**From:** [REDACTED]  
**Sent:** 03 May 2022 03:27  
**To:** Planning  
**Subject:** Planning Application No: 3/2022/0218  
**Attachments:** Screenshot\_20220503-030805\_Gallery.jpg; Screenshot\_20220503-023144\_Gallery.jpg; Screenshot\_20220503-023634\_Gallery.jpg; Screenshot\_20220503-023810\_Gallery.jpg; Screenshot\_20220503-023955\_Gallery.jpg; Screenshot\_20220503-023803\_Gallery.jpg; 20220502\_140313363.jpg; Screenshot\_20220503-022745\_Gallery.jpg

Application Number - 3/2022/0218

Address - Shireburn Caravan Park, Edisford Rd, Waddington, BB7 3LB.

Proposal: Variation of condition 5 (closure of existing access to all traffic except for access to the lodge and emergency access to the site) of planning permission 3/2004/0806 to provide free site access to the caravan park via the southern road.

Screenshot of Southern Access

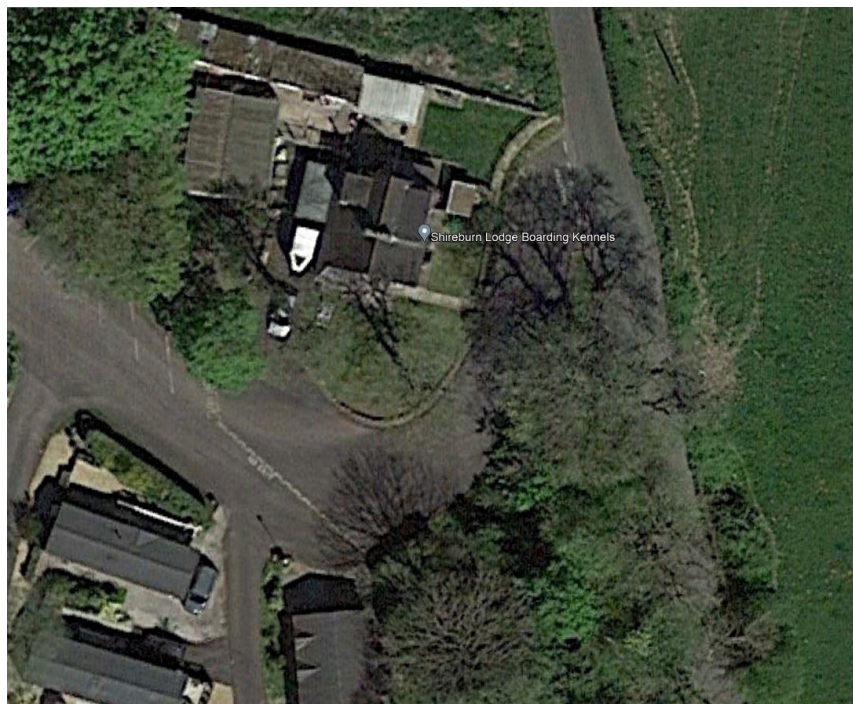
Technical note: highways suggest narrowing the interface, however, there are no plans showing how this could be done. When entering the southern access, the road branches off to the left to Birch Drive, to the right to Shireburn Lodge Kennels, straight on past the kennels to shireburn house and there's also a car park to the right. I fail to see how this could be narrowed without restricting access. Due to the car park being put in front of the kennels there's only just enough room to back off the drive as things stand. [REDACTED] and can't have my access restricted any more. Shireburn Lodge Kennels also has a right of way right up the drive past the top of the kennels, this can't be blocked.

I have grave concerns for pedestrians and cyclists should the access be re-opened to the site. The majority of foot traffic uses the southern entrance, that includes children, the elderly and pets. There is no footpath and visibility entering the site is poor. Shireburn Lodge Kennels front path also comes out on to the access road. Delivery drivers in particular drive at speed around the site and should the access be open I fear there would be a serious accident as it would be impossible for pedestrians/cyclists to get out of the way and drivers wouldn't see them until it's too late. It wouldn't just be cars entering the site but HGVs and vans.

DRAWING NO: 2200201

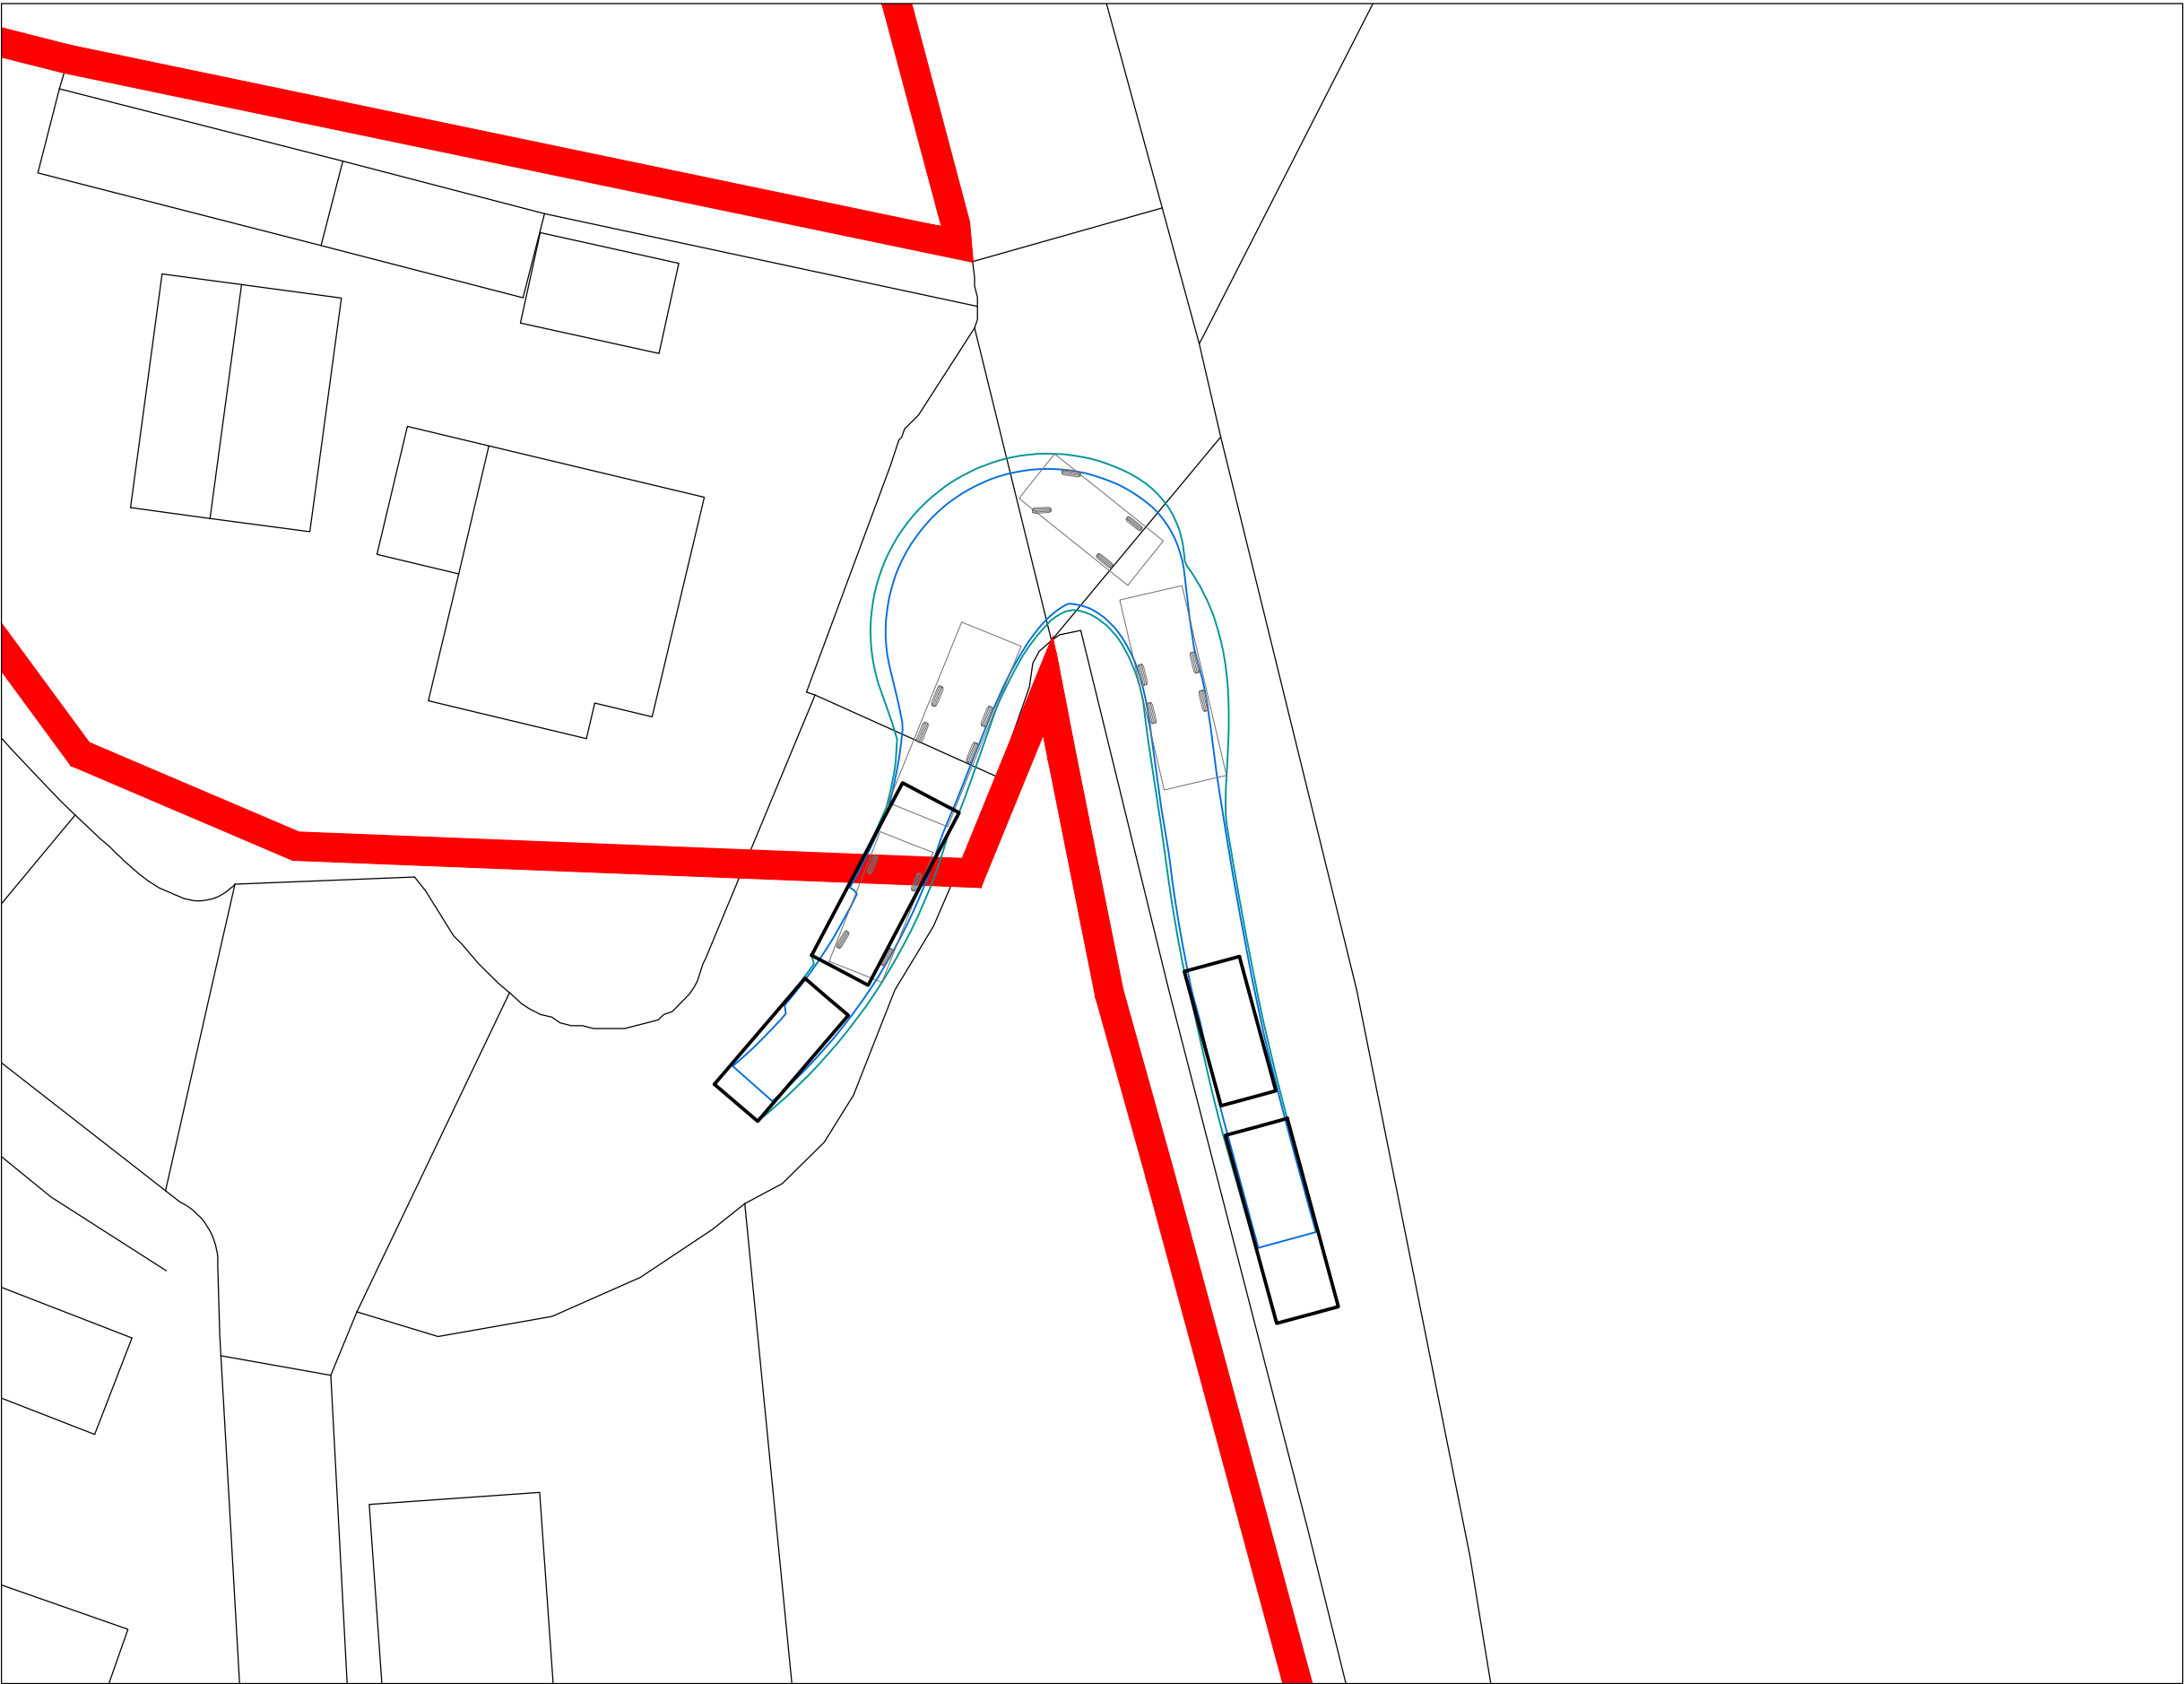
Technical Note: Highways seem to suggest the site is used for touring caravans with addressing maps, directions to the site and entering the site towing a caravan. Shireburn caravan park is not permitted to have touring caravans so no cars towing caravans currently use the northern access as stated in the technical note. I fail to see how this information has any relevance to this application.
